Please ask for: Sian Eggington
Email: sian.eggington@terraquest.co.uk
Telephone: 0121 2341390
Our Ref: BN/88/20/HH
Your Ref:
Date: 12th August 2020

Application for Planning Permission for Works or Extension to a Dwelling

Development: REMOVAL OF EXISTING CONSERVATORY AND 'STUDIO' OUT-BUILDING TO REAR OF PROPERTY AND CONSTRUCTION OF SINGLE-STOREY EXTENSION TO REAR AND PROVISION OF FIRST FLOOR ACCOMMODATION OVER EXISTING BUNGALOW.

Location: 55 Elm Grove Barnham PO22 0HJ

55, Elm Grove, Barnham, West Sussex, PO22 0HJ - Block Plan

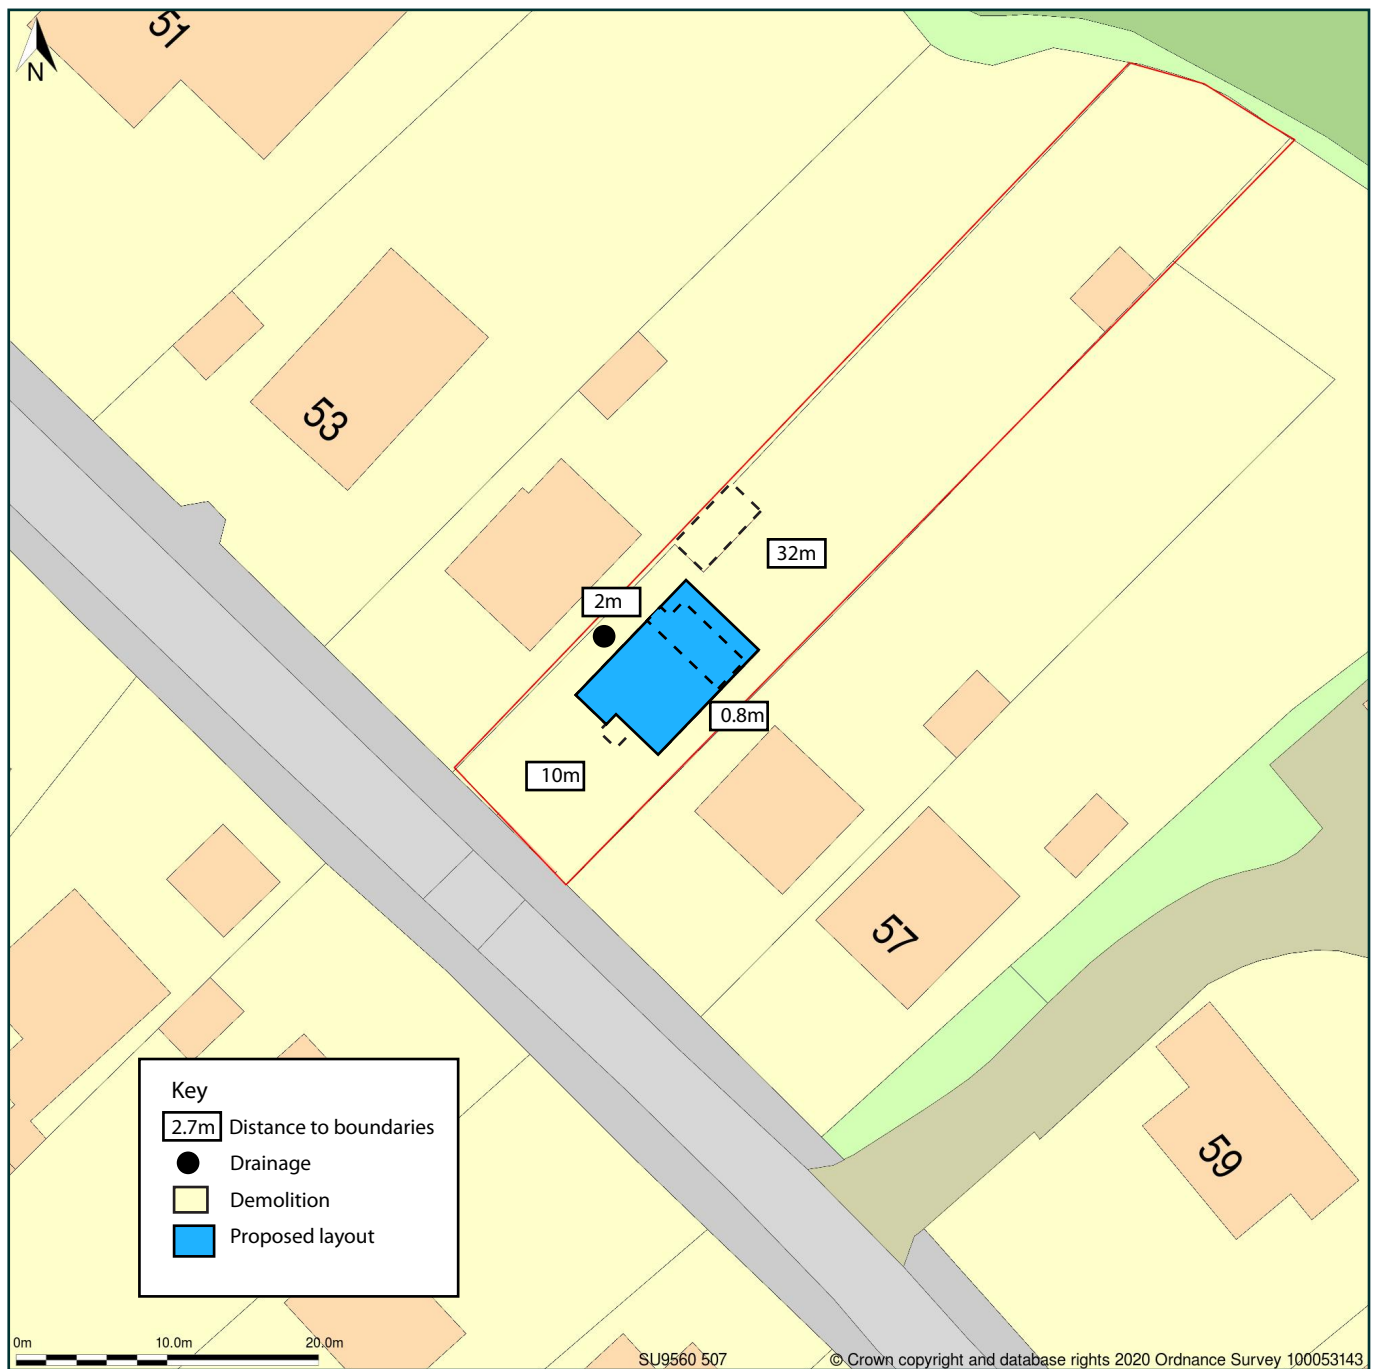
Block Plan: You are required to submit a proposed block plan with dimensions to all site boundaries.

GROUND FLOOR PLAN
SHOWING REPLACEMENT EXTENSION & ALTERATIONS

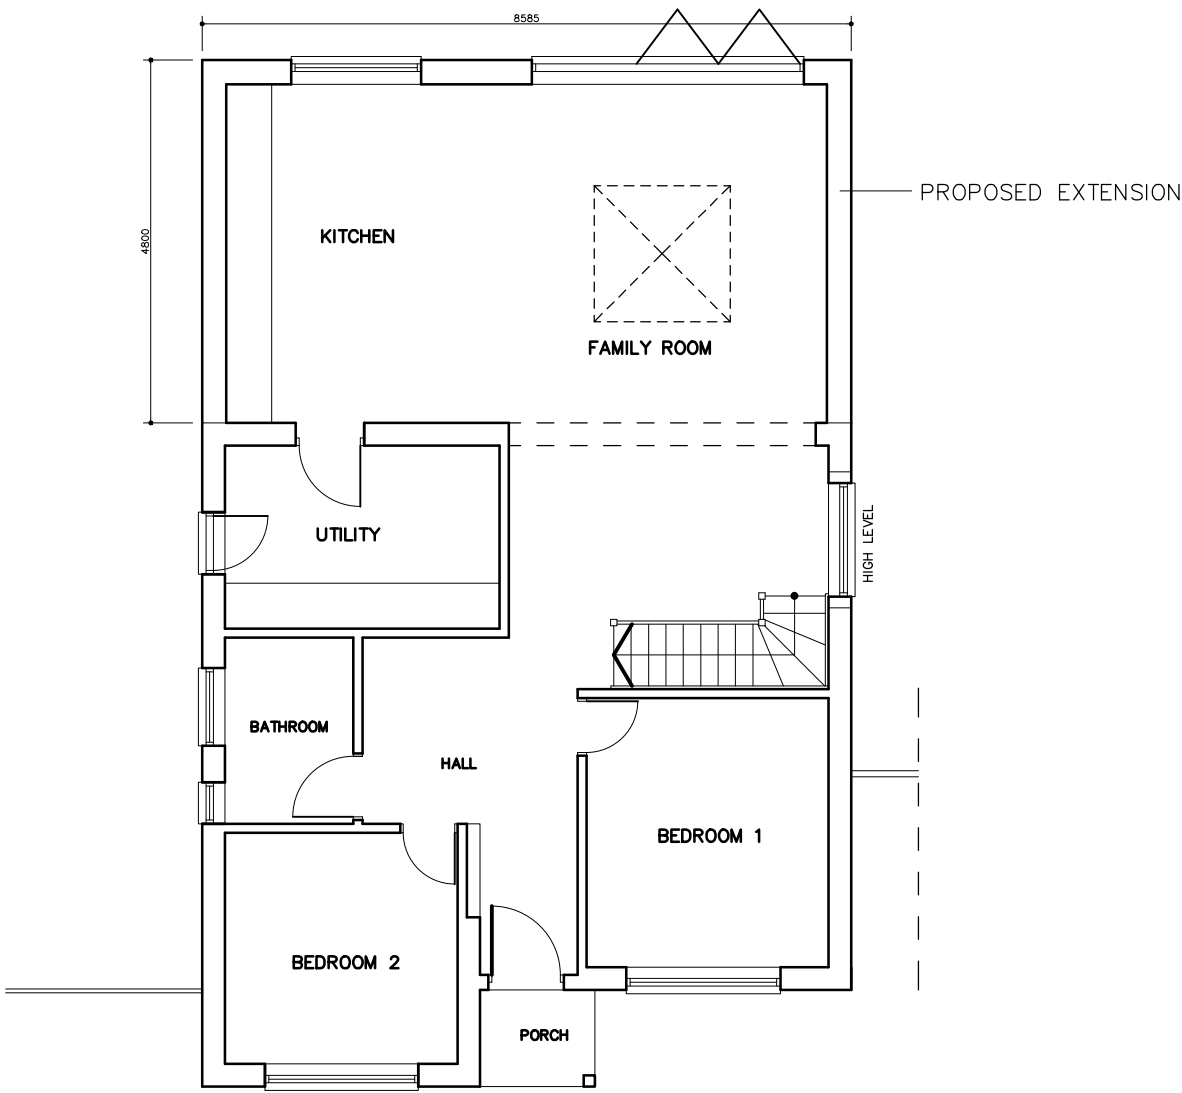
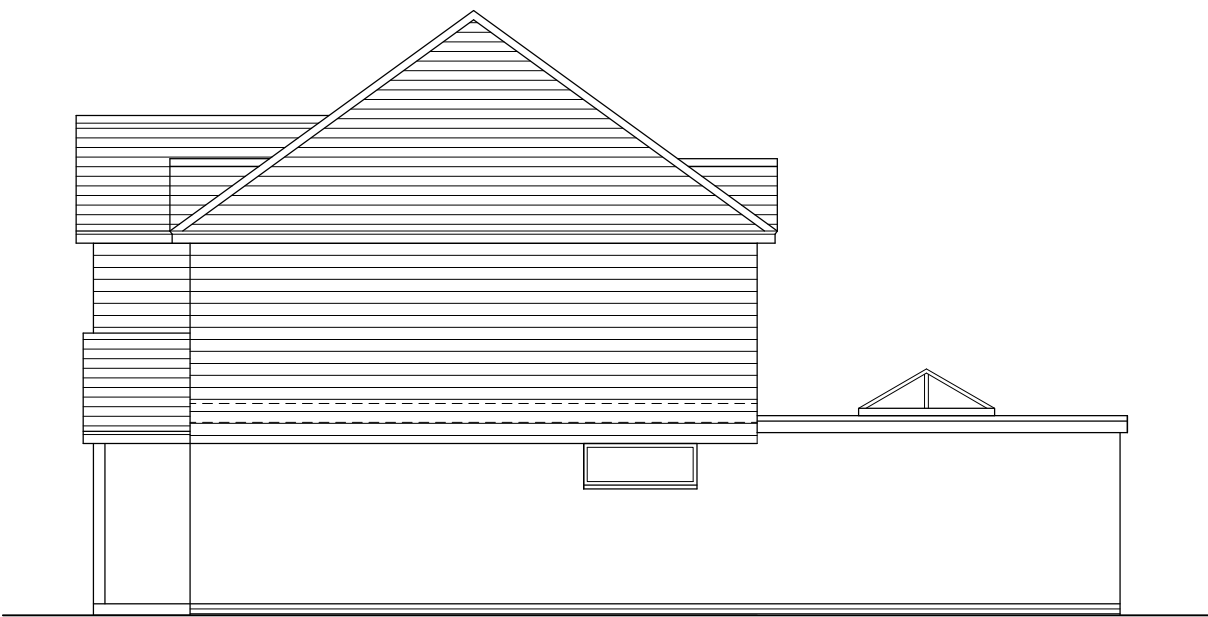
Porch: You are reducing the size of the existing porch. This needs to be included in the description. With your permission we can add this for you.
